Recommendation Report for Planning Permission for Works or Extension to a Dwelling

REF NO: LU/381/14/HH

LOCATION: 70 Southfields Road
Littlehampton

PROPOSAL: Proposed dropped kerb. This application may be determined by Littlehampton Town Council under delegated powers

Block Plan shows area bounded by: 504007.27148438,102344.30273438 504097.27148438,102434.30273438 (at a scale of 1:500) The representation of a road, track or path is no evidence of a right of way. The representation of features as lines is no evidence of a property boundary.

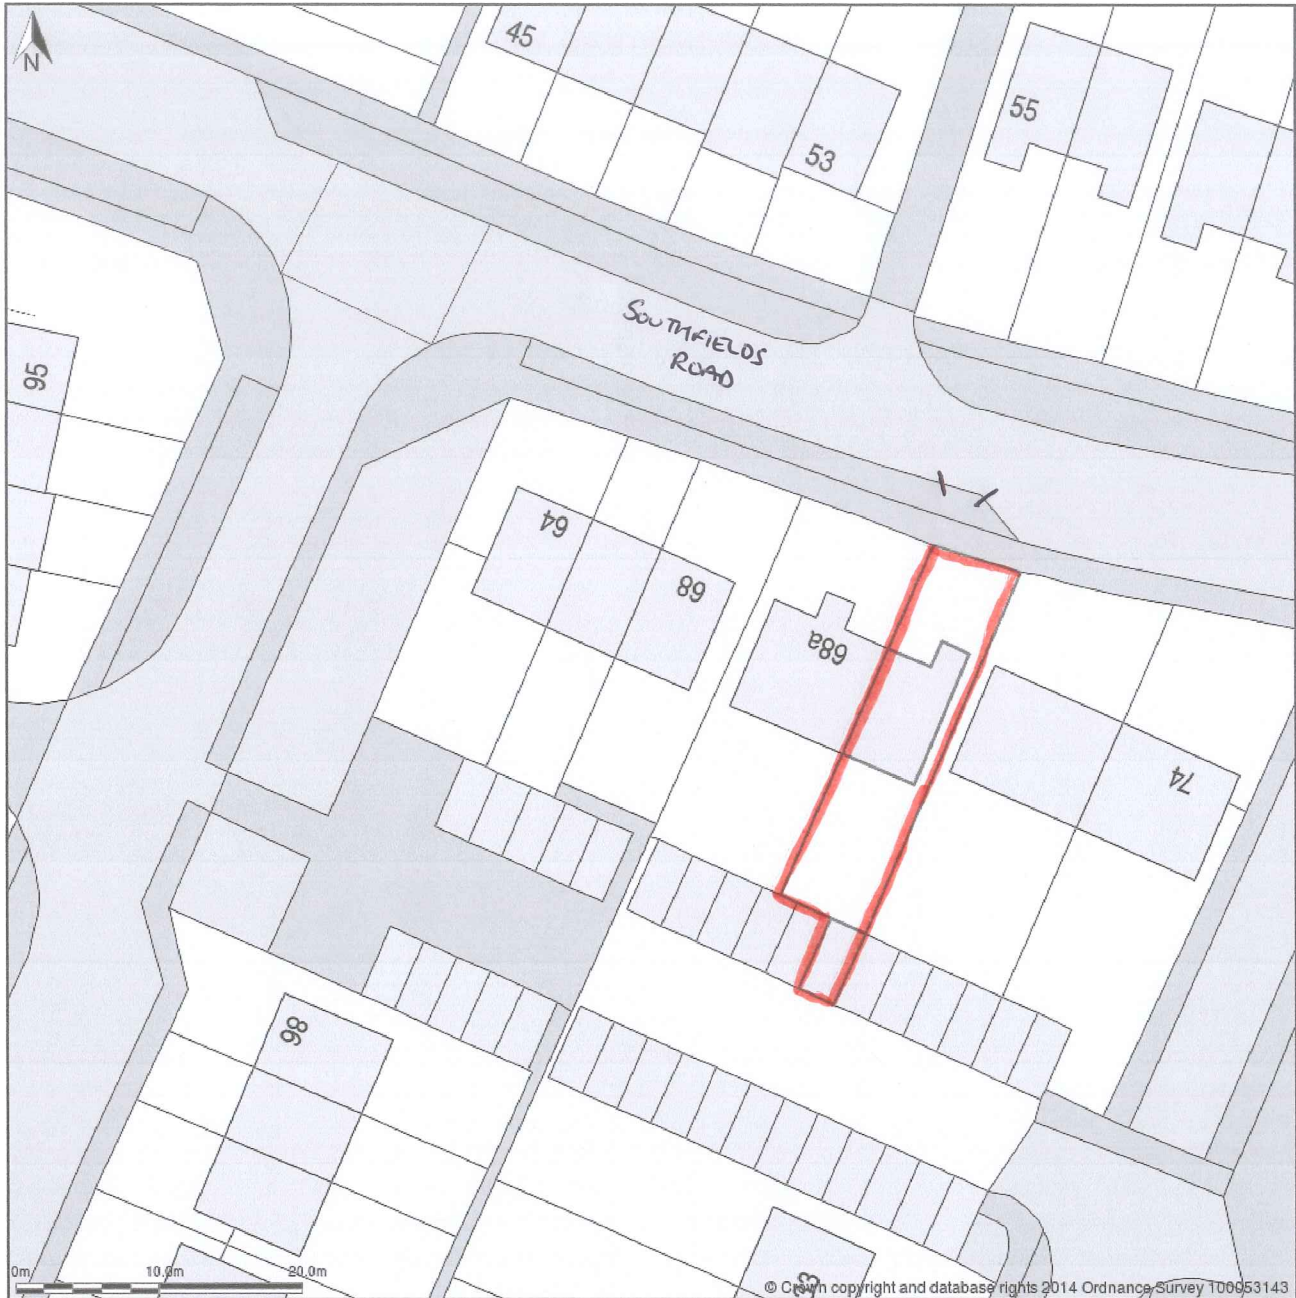
The precedent of vehicle crossovers along Southfields Road has already been set. Appropriate visibility splays of 2.4m x 43 metres can be achieved wholly within highway land. It is noted that the crossover will be construed on the western extent of the property frontage. The crossover should not therefore interfere with the existing layby or the existing street lighting column.

The crossover must be constructed under licence to a specification obtained from WSCC Highways. No details have been provided pertaining to any proposed hard standing area for vehicle parking. This area must measure 2.4 x 4.8 metres and be constructed in a bound material. I would ask these details are secured via condition.

- 3 The visibility splay either side of the approved access shall be set at 2.4 x 43 metres and splay areas shall be kept free from any obstruction to visibility in excess of 0.6 metres above the level of the adjoining carriageway and retained in perpetuity thereafter.

- 4 No works shall commence until details have been submitted to and approved by the Local Planning Authority regarding the area of hard standing for vehicle parking/access to be constructed in a bound material and these details so approved shall be implemented with the permission and be retained thereafter.
